*Submission to El Paso Co Planning and Community Development is prefaced with the understanding that entities associated with Eagle Rising Filing No.1 (project name) have proven extremely litigious individuals. No less than **three** adjacent property owners have had extensive lawsuits filed against them and **additional** land owners served with cease and desist letters from Eagle Rising land owners. Individual home owners are not in the position to enter into what is certain litigation with the Eagle Rising developers. Therefore comments will remain anonymous.*

W.E. (E.W.) believe Eagle Rising developers are attempting to gain free, permanent and exclusive, access to property owners' land outside of and adjacent to the proposed Eagle Rising Filing No.1 plat (see west boundary of attached). W.E. believe Eagle Rising developers intend for this to result in limited and gated access to the extended portion of Eagle Wing Drive (labeled Eagle Wing View) defined as "private" on Eagle Rising Filing No.1.

Please require Eagle Rising developers to fully declare intentions regarding the Eagle Wing Road turnaround outside of the Eagle Rising Filing No.1 plat and answer these questions:

SHEET 2 OF 2

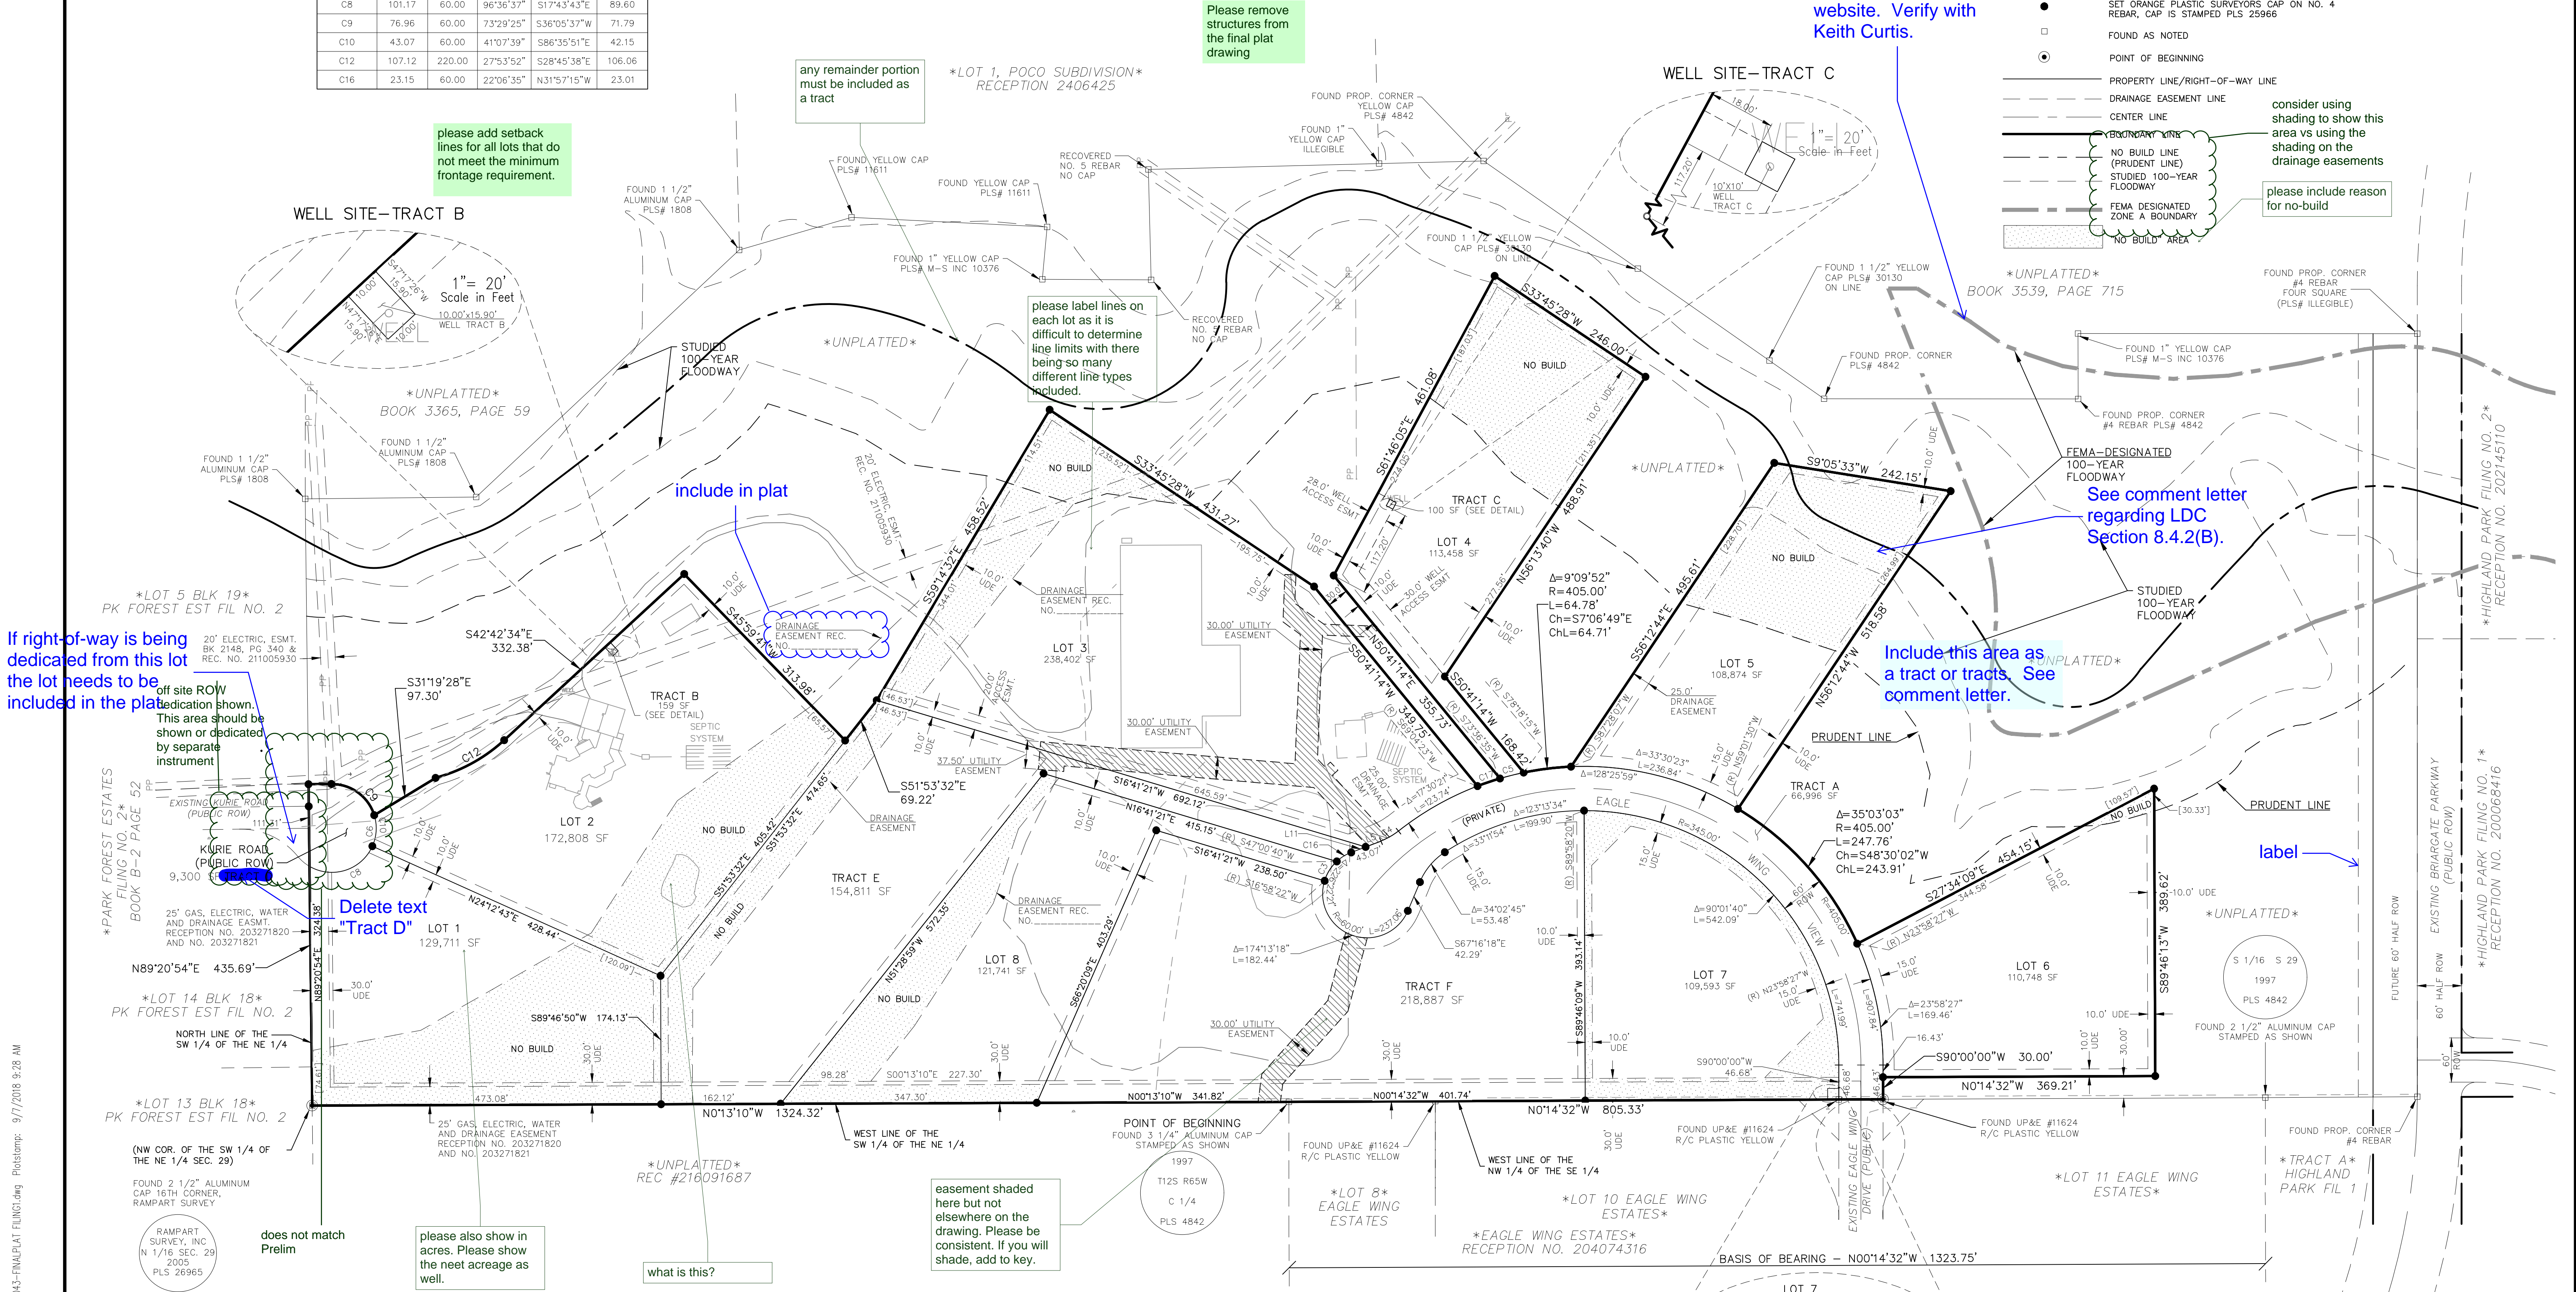
Using the Final Plat Drawing included with this submission, the dotted lines W.E. have highlighted have NO definition. W.E. believe this is intentionally vague and intended to deceive County reviewers. These dotted lines are not property owner boundaries. Nor are these dotted lines County Right of Way. In fact, the dotted lines represented by the Eagle Rising developers cross **private property** and have NO factual basis.

W.E. believe these markings, outside of the Eagle Rising Filing No.1 plat, will be used to force property owners to acquiesce their property to a dedicated turnaround, locked outside of a gated Eagle Rising private roadway if the plat is approved as is. This action by the developers forces all Eagle Rising View traffic, delivery vehicles, service vehicles, etc. to remain outside of Eagle Rising (note community mailbox platted) yet fully servicing the gated/private housing development.

Is this gated? Is the gated approach approved?

Is this a Right of Way change?

Will the County take over maintenance, drainage, etc?

Will the property owners be forced to bring to County Right of Way standards?

Will property owners be compensated?

Is this approved for gated access?

Is this shaded area (and opposing side) being donated to the County?

What is the basis for these lines? County R.O.W.? Property lines?
